Our Ref: SDNP/23/03514/PRES
Contact Officer: Shazia Penne
Tel. No.: 01403 215187

PRE-APPLICATION ADVICE

Applicant Name: Michael Modlock
Proposal: Householder extensions and associated works.
Site Address: Sandrock, Old London Road, Coldwaltham, Pulborough, West Sussex, RH20 1LF

Dormer Window

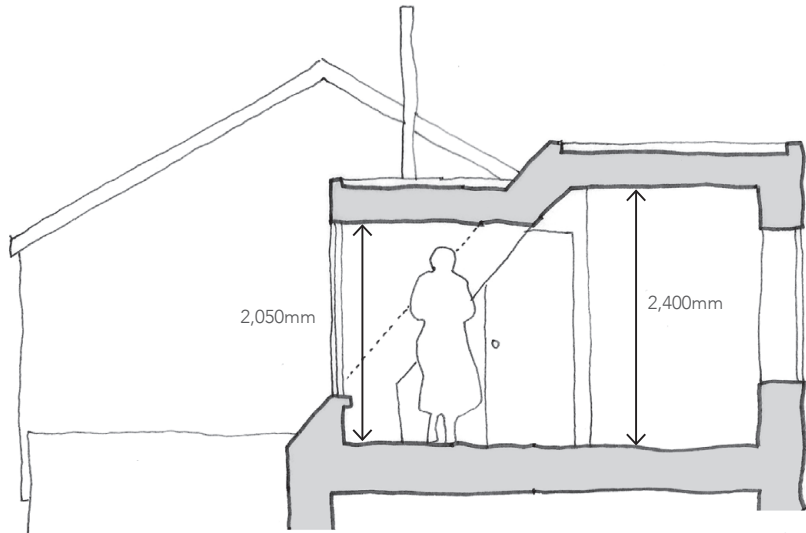
The site is located within Dark Sky Zone E1(a), which is an area of intrinsic rural darkness. The submitted drawings, shows the introduction of a large, glazed dormer window to the front elevation of the dwelling. Given the proposed residential use of the building, some concern would be raised regarding the light emittance from the glazed aspects of the building and the impact this would have on the dark night skies within the National Park. Any application submitted for this proposal should include a statement which outlines the measures that will be taken to reduce light pollution to the dark night skies within the National Park.
